**From:** [REDACTED]  
**To:** [Hinckley SRFI](#)  
**Subject:** Hinckley National Rail Freight Interchange: response to letter  
**Date:** 31 December 2024 10:14:07

Ref: Triutax Symmetry Additional Information 10th December 2024  
Secretary of States Letter of Response 20th December 2024 to interested parties.

Interested Party Reference number: 20037615

Section D-D - Fence Option

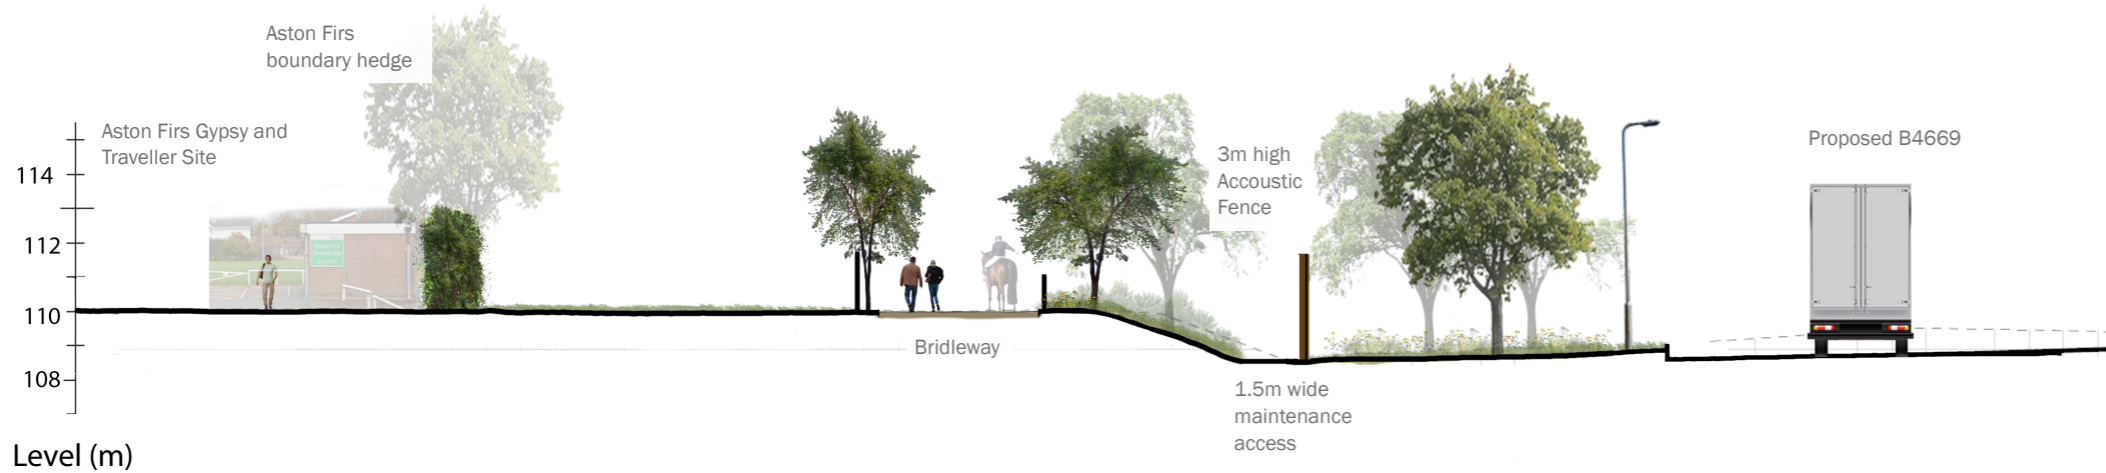
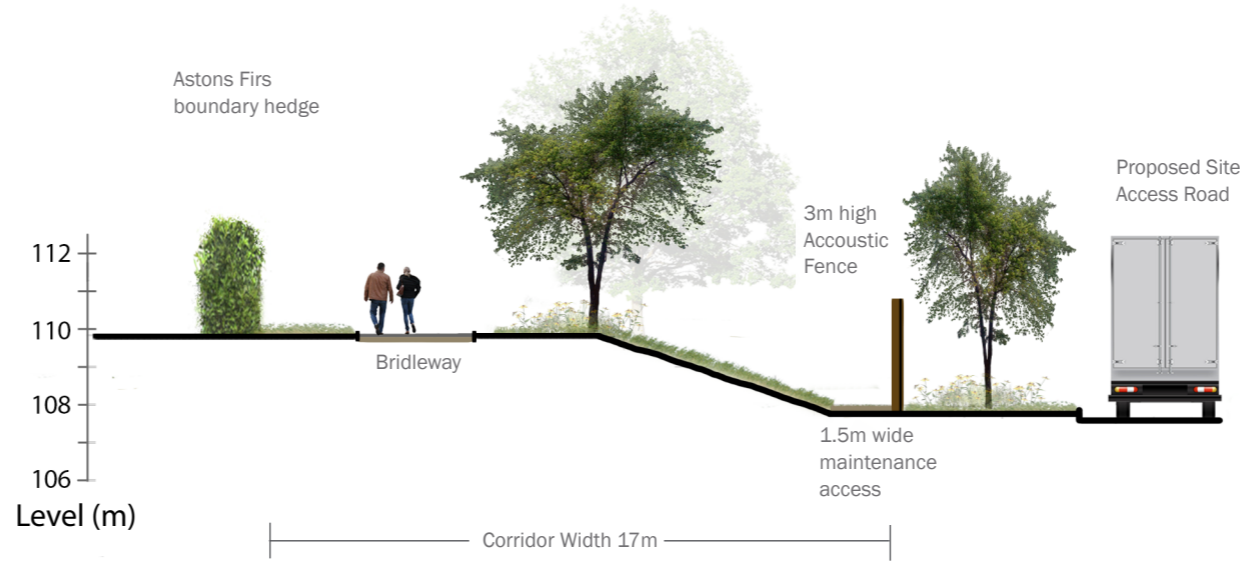
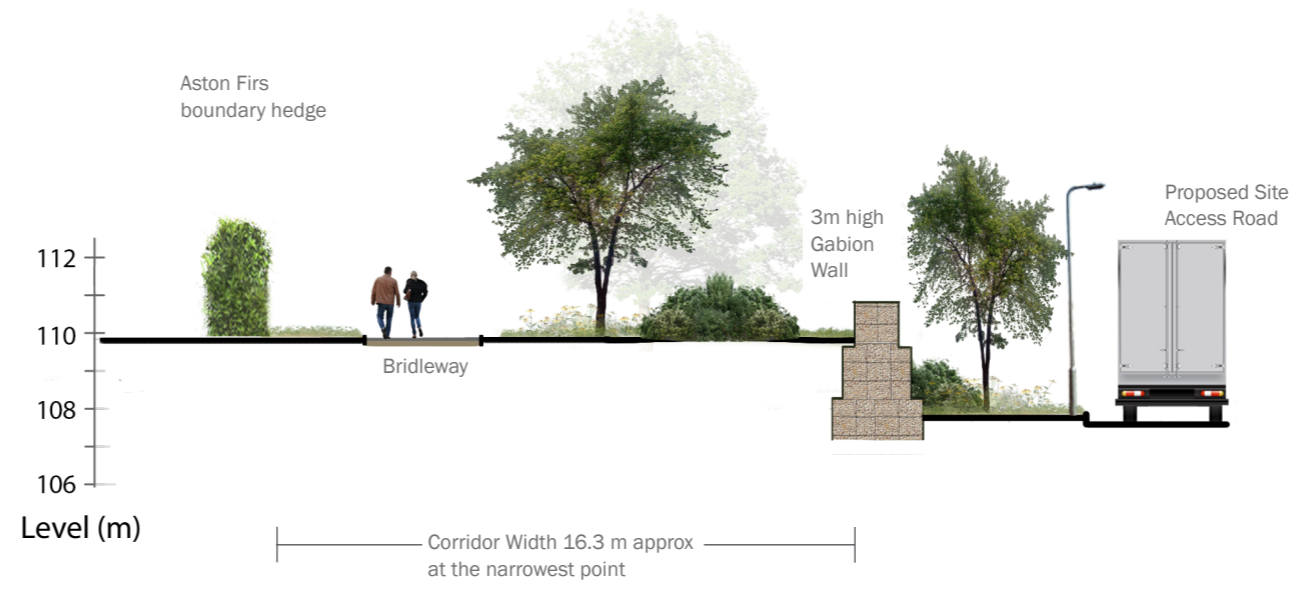
What will these 3 and 4 meter Sound Barriers look like? Will they be screened in some way from the homes on the Aston Firs site?

What about the levels of noise coming from the gap in the Sound Barriers as access to the Bridleway? Could the Sound barriers not be situated in such a way that they are staggered, maybe, to allow less noise to disturb the Aston Firs residents?
